Consultation Response from: KC Environmental Health (Pollution & Noise Control)

2026/92071 Co-Op Academy Smithies Moor, Leeds Old Road, Heckmondwike, WF16 9BB

Discharge of details reserved by conditions 7 (gas risk assessment) and 18 (site stabilisation) on previous permission 2025/92598 for redevelopment of school, including demolition of existing buildings and construction of replacement single storey school building with external works including provision of a forest school, hard and soft PE and play spaces, car and cycle parking, bin store, sub-station, pedestrian and vehicle access and landscaping

Responding Ref:
WK202624541

Figure 4-1 - Grouting Grid Post Treatment - SRP1128-HEX-XX-XX-D-S-0002-P01

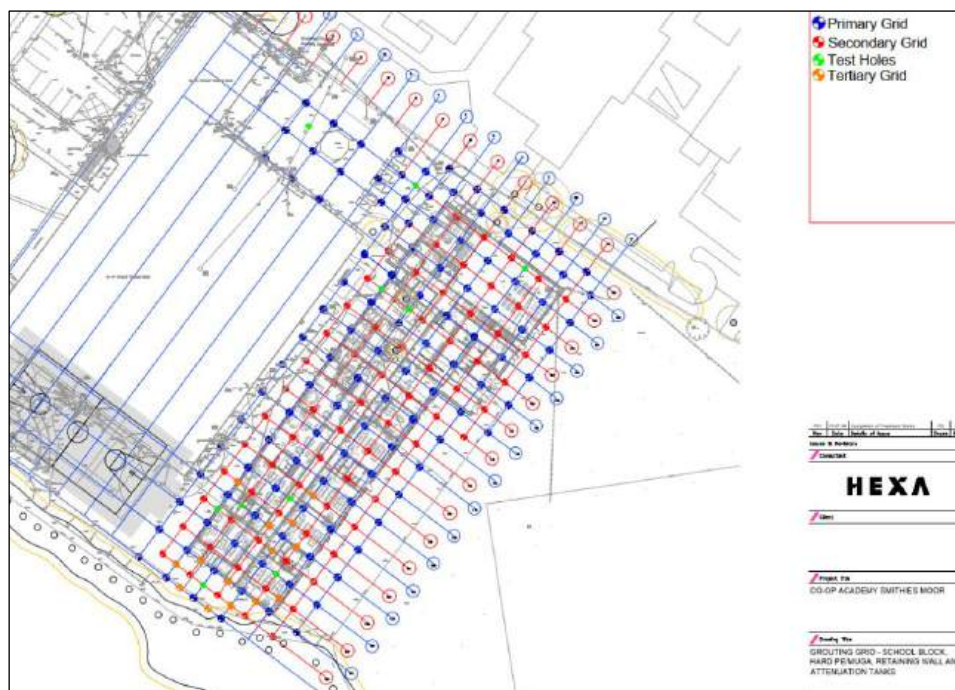
The revised conceptual site model (CSM) identifies the historic mine workings as the only theoretical source of ground gas but concludes that no significant source has been demonstrated. The extensive drilling and grouting works completed to date (illustrated in the drawing 'Grouting Grid - School block, hard PE/MUGA, retaining wall and attenuation tanks') are considered to have substantially reduced potential migration pathways and the likelihood of any unrecorded mine shaft within the treated Phase 1 area is very low. The assessment concludes the ground gas risk remains unchanged following the stabilisation works and that the site should continue to be classified as CS1 and that no specific gas protection measures are required for the proposed school building and that no further ground gas assessment is necessary for the Phase 1 development area.

The post-grouting ground gas risk assessment and revised CSM demonstrate that, following completion of the Phase 1 stabilisation works, the treated area remains characterised as CS1. The assessment confirms that no ground gas was detected during the drilling, grouting or validation works and concludes that no specific gas protection measures are required for the proposed school building.

The submitted Hexa report relates solely to the completed Phase 1 treatment area, comprising the proposed school footprint, the Phase 1 attenuation tank and part of the Phase 2 attenuation tank. The report confirms that additional stabilisation works remain to be undertaken within the wider Phase 2 area following demolition of the existing school building and that the findings of those works should be reviewed through an updated ground gas risk assessment and conceptual site model.

Environmental Health have no objection to the details of Condition 7 being partially approved in relation to the Phase 1 development area only. However, we would recommend that Condition 7 remain in place for the remainder of the site pending completion of the Phase 2 stabilisation works and submission of an updated ground gas risk assessment demonstrating that the conclusions remain valid for the Phase 2 development area.
